T-Bone Construction, Inc.
1310 Ford St.
Colorado Springs, CO 80915
(719) 570-1456 Fax (719) 591-5217
5 October 2020

LETTER OF INTENT

2. Site Location, Size and Zoning:
- a. Location: 7615 McLaughlin Road, Falcon, CO 80831.
 - b. Legal Description: Lot 4 Woodmen Hills Fil No 7
 - c. Size: 1.64 acres.
 - d. Zone: CR
 - e. Parcel Schedule No.: 4306301002
3. Request for replat the current property into three separate parcels; Lot #1 (34,796 sf) for future commercial development, Lot #2 (34,633 sf) for future commercial development, and Tract A (1,886 sf) intended for access to the west end of the exiting shopping center.

AS REPLATTED

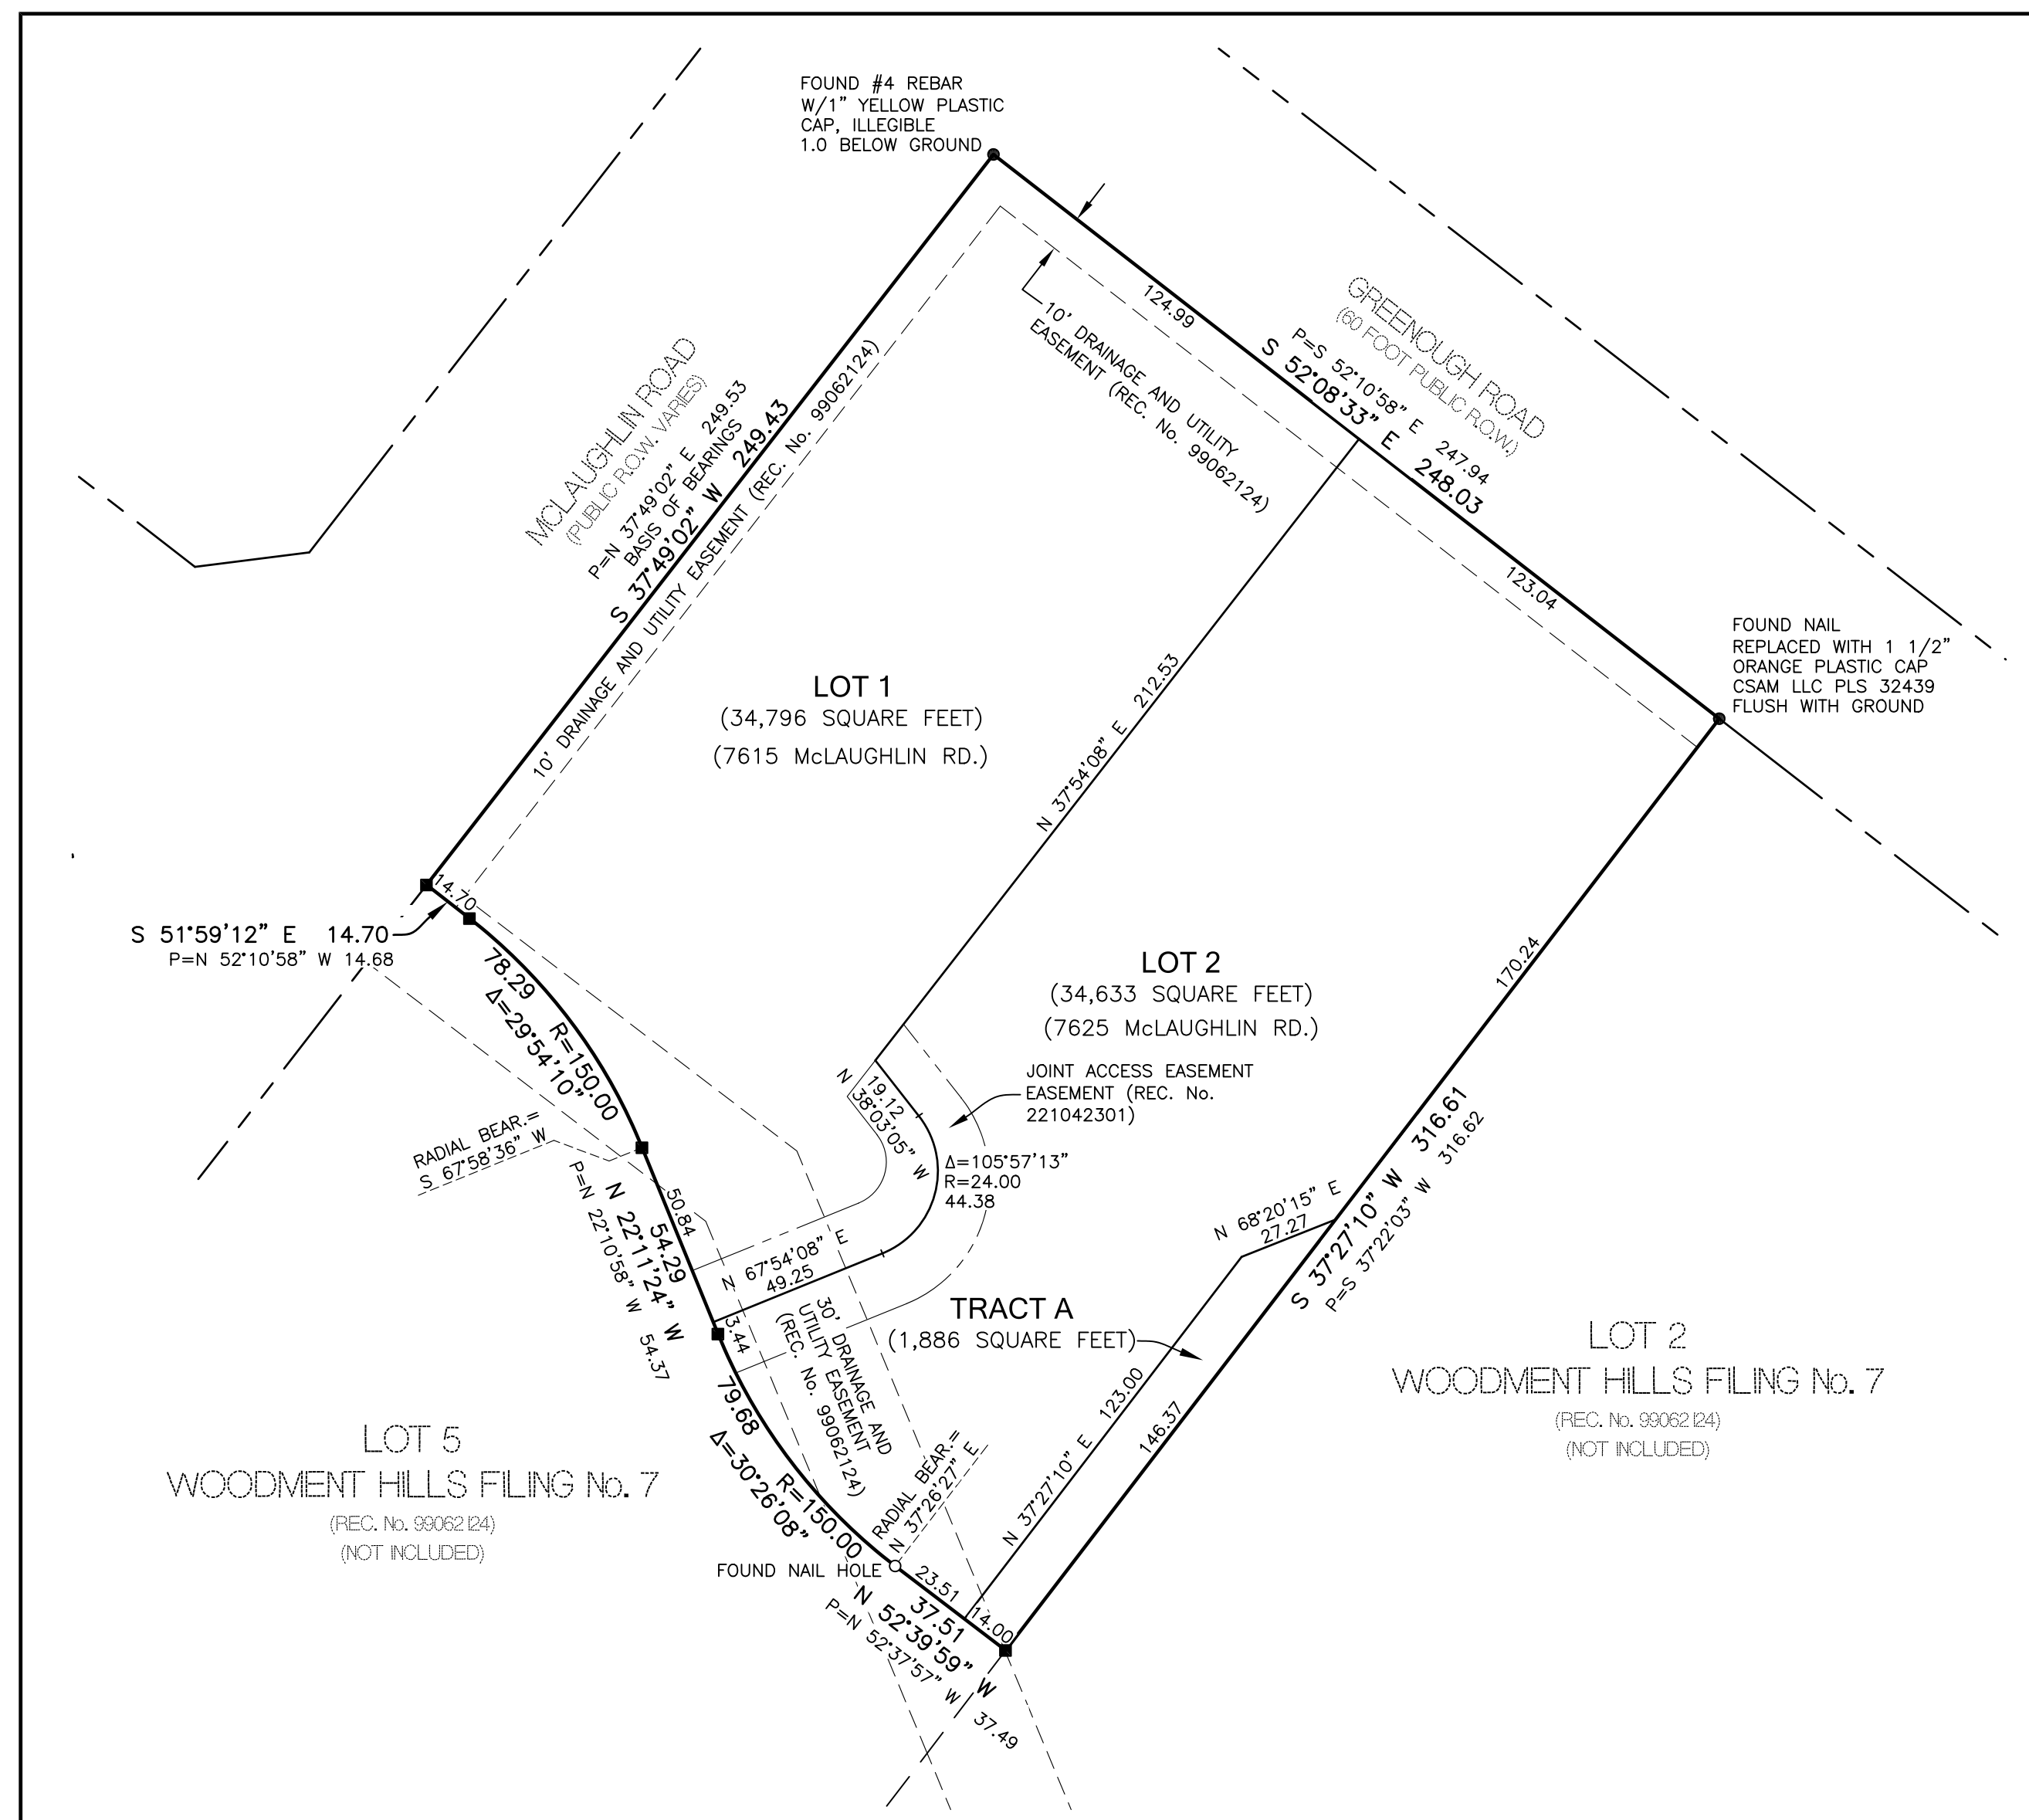
Call out the what happens to the access road that bisects Lot 2.
